Recommendation Report for Planning Permission for Works or Extension to a Dwelling

REF NO: EP/157/19/HH

LOCATION: St Briac
South Strand
East Preston
BN16 1NY

PROPOSAL: First floor extension and changes to cladding and finishes.

Project: Proposed extension; St. Briac, South Strand, East Preston BN16 1NY	
Drawing: Elevations as proposed	
For: Mr. J. Trusson & Ms. L. Byrne	
Drawn: PKS	Date: November 2019
Scales: 1:100	No: 2510/01/03
To scale when printed on A3

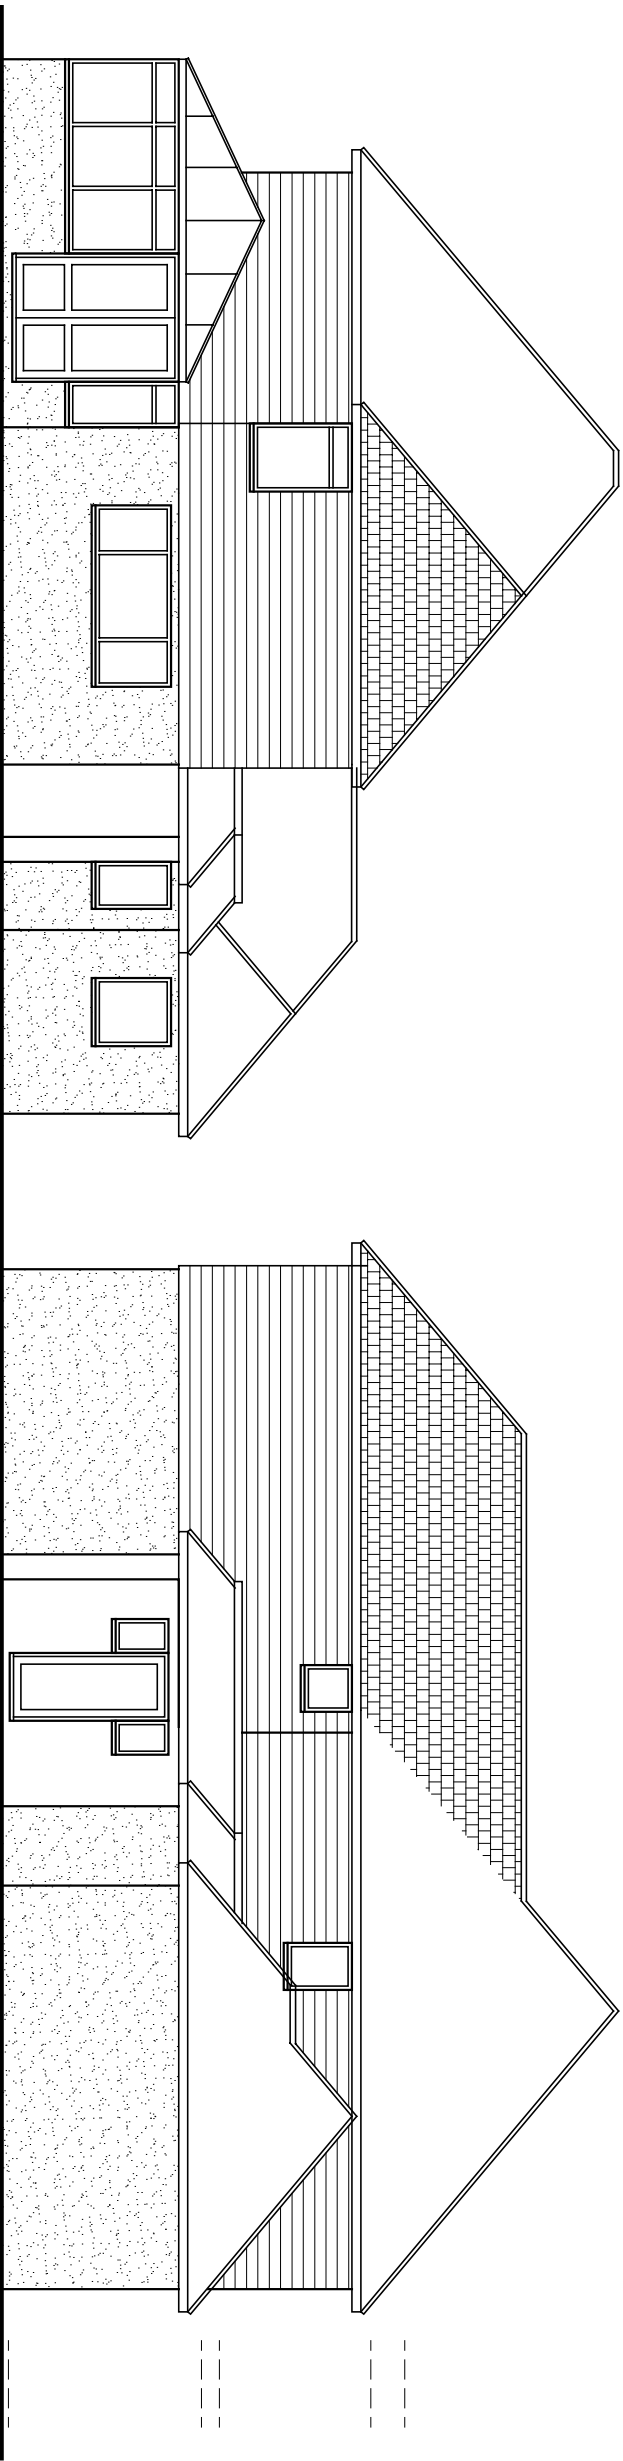
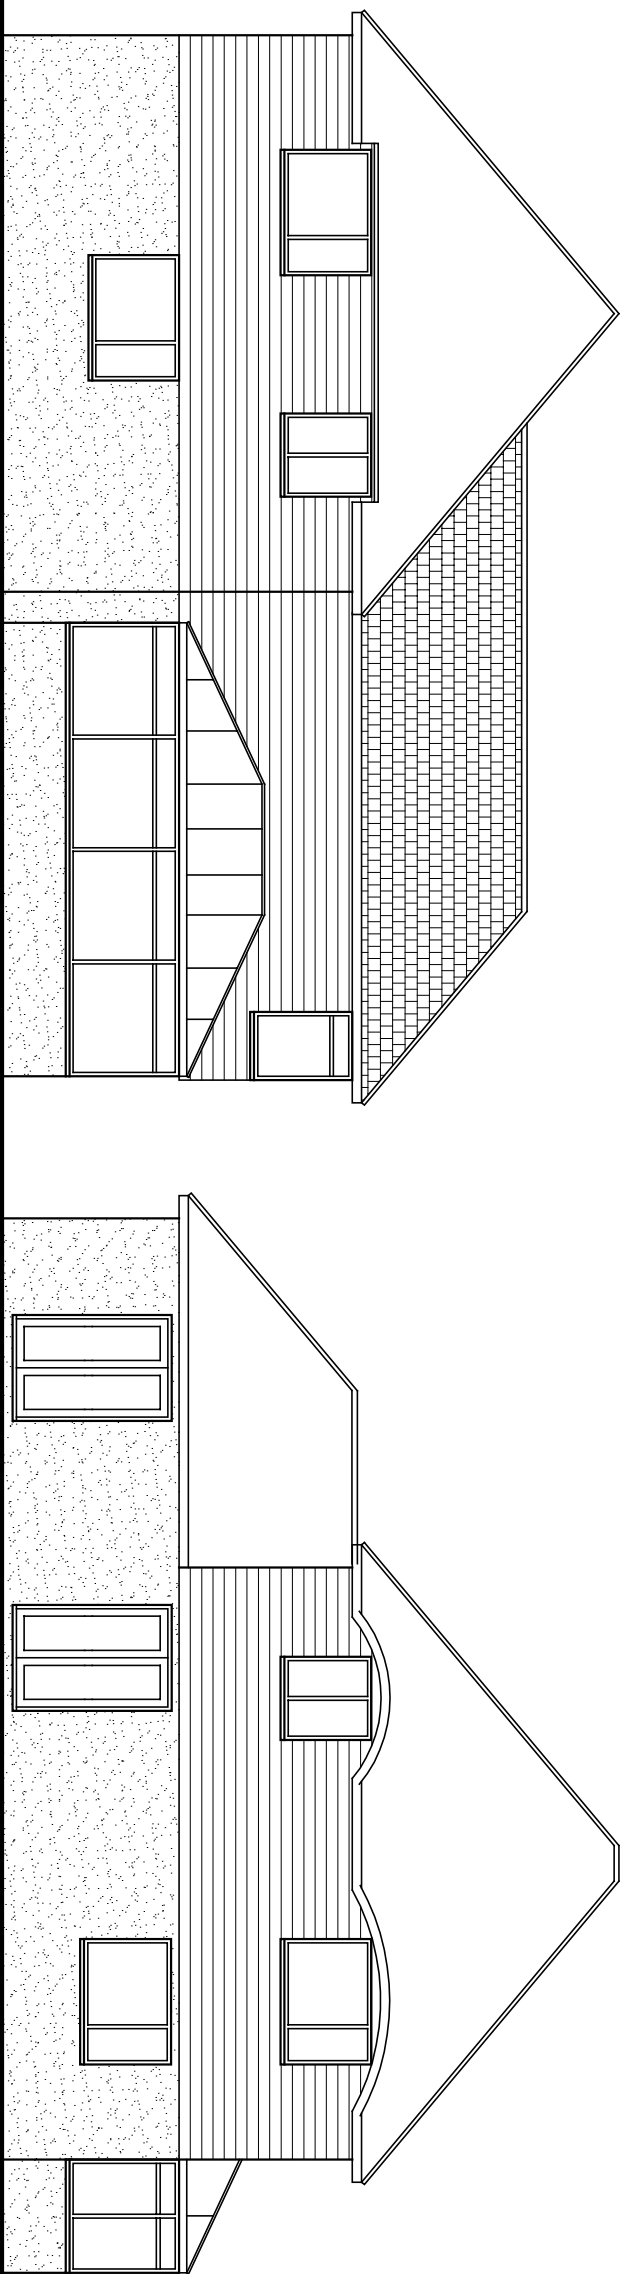
- The Parish object to the proposed materials, in that they would not harmonise with neighbouring properties.
- The Marley Cedral boarding and the coloured render is inappropriate. for the area.

- The use of grey cladding would introduce a materials alien to its surroundings.
- The materials would not harmonise with the area.

The application seeks to change the materials of the host dwelling, largely relating to its walls. This includes the provision for off-white render and grey cement boarding. Given the presence of these materials within the locality, and the varied mix of building styles and appearances within the area, the proposed materials are not considered to result in any significantly harmful impact upon the character of the host dwelling, or its locality.

With regard to potential overlooking, the proposed development is not considered to give rise to any loss of privacy to neighbouring dwellings. Whilst it is noted that the proposal features a window of which looks towards the dwelling to the East, it is considered that due to intervening boundary treatment, and the separation distance, there are not considered to be any views of which harmfully affect the occupants of this neighbouring dwelling. To the North, the boundary of the application site is over 20m away, which is considered to be a significant distance, and as such mitigate any potential for overlooking. To the West, it is noted that there is a window, serving a bathroom, which may give rise to views into first floor windows of the building to the West. As such, a condition will be imposed, ensuring that this window is obscure glazed and non-opening below 1.7m from internal floor level.

- 3 The window at first floor level in the Western elevation of the building shall at all times be and remain glazed entirely with obscure glass, and be non-opening, below 1.7m from internal floor level.
